Ribble Valley Borough Council
Housing & Development Control

Your ref 3/2022/0047
Our ref D3.2022.0047
Date 30th March 2022

Application no: **3/2022/0047**

Proposal: **New access to the highway (following the blocking off of existing) and extension to existing agricultural building.**

SITE PLAN SCALE 1:500

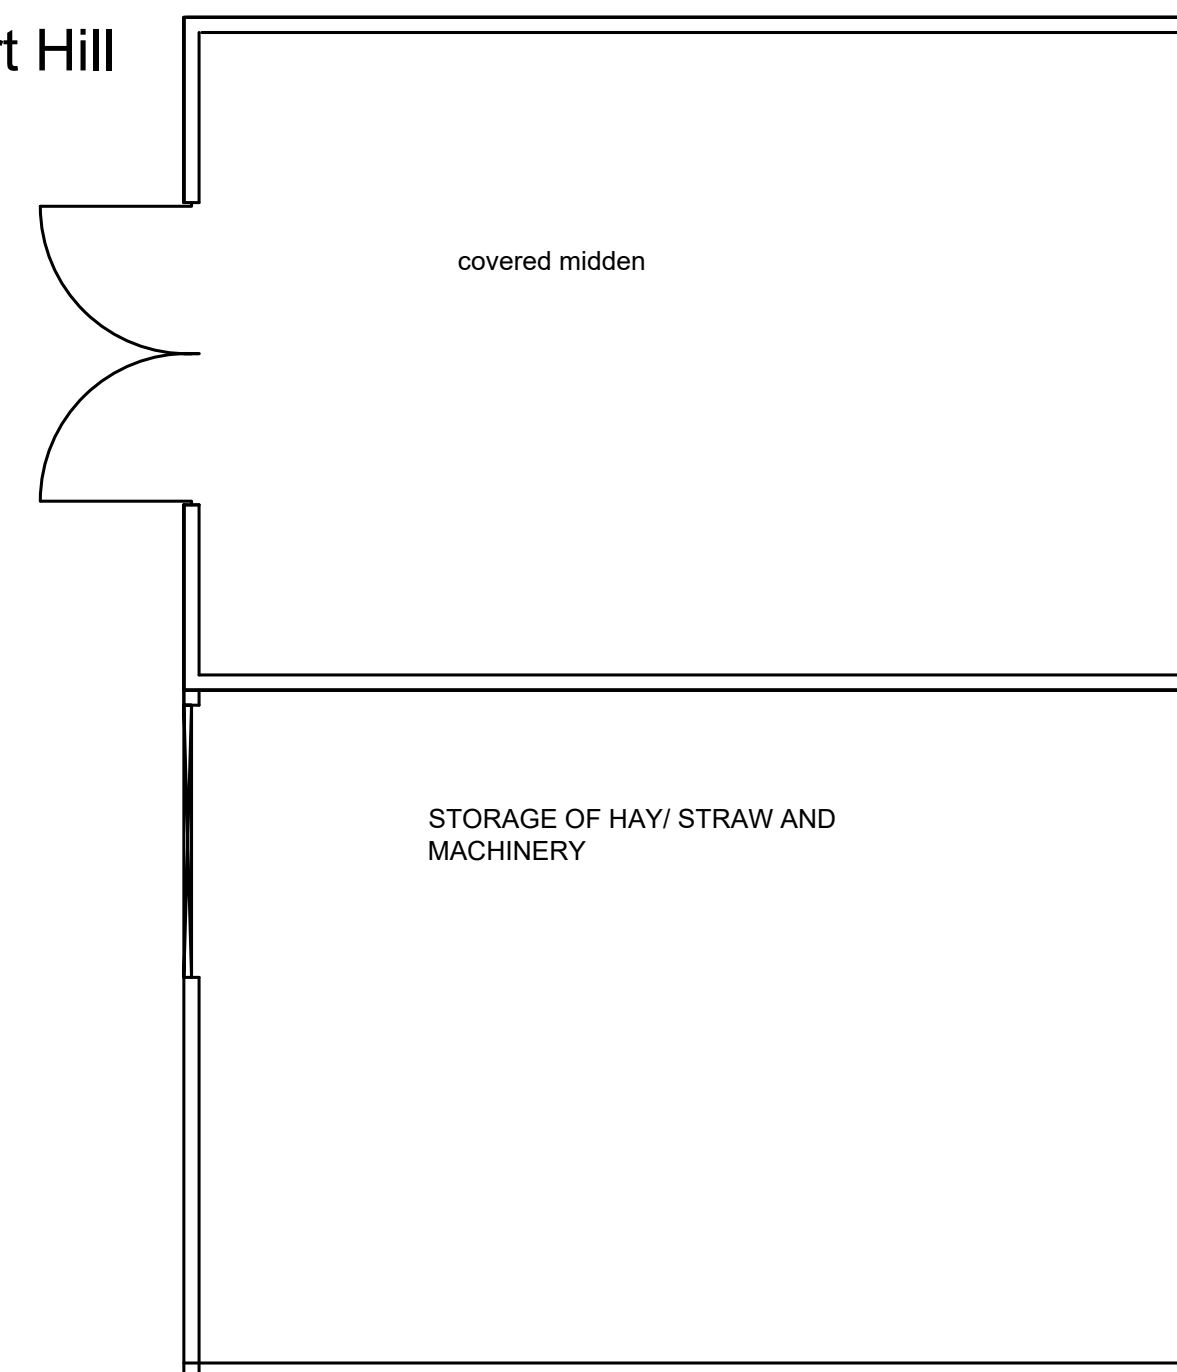
The LHA are aware that the proposal is aiming to relocate the site access, approximately 10m to the west along Garstang Road. The existing access will then remain as existing but will only be used to serve pedestrians with Public Footpath 3-12-FP74 going through the site.

The LHA have reviewed ML drawing number SP/EH/4026a titled "Proposed Site Plan" and are aware that the existing access will be reduced to 2m wide to ensure that only pedestrians will use the access. The LHA advise the Applicant to contact the LHAs Public Right of Way team, please see informative below, to discuss the type of pedestrian gate which will be suitable for the access.

The LHA have also reviewed the proposed access and are satisfied that the access width and the setback distance of the gate complies with the LHAs guidance.

Furthermore, the LHA have reviewed the sites visibility splays and are aware that the site can provide visibility splays of 2.4m x 180m to the left and 2.4m x 215m to the right of the access.

While the LHA are aware that the visibility splay to the left of the access does not comply with the LHAs guidance, which requires a 60mph road to provide visibility splays of 215m in both directions and that the splay to the right is unlikely to be able achieve the minimum visibility due to the topography along Garstang Road, the LHA will accept any shortfall.

This is because speeds along Garstang Road are unlikely to reach speeds in excess of 60mph, given the narrow nature of the carriageway and the topography of the road. Therefore, the LHA will accept any shortfall in visibility and so have no objection to the proposal.

1. No part of the development hereby permitted shall be occupied until such time as the access arrangements shown on ML drawing number SP/EH/4026a have been implemented in full.

4. Nothing shall be erected, retained, planted and / or allowed to grow at or above a height of 0.9 metres above the nearside carriageway level which would obstruct the visibility splays shown on ML drawing number SP/EH/4026a. The visibility splays shall be maintained free of obstruction at all times thereafter for the lifetime of the development.
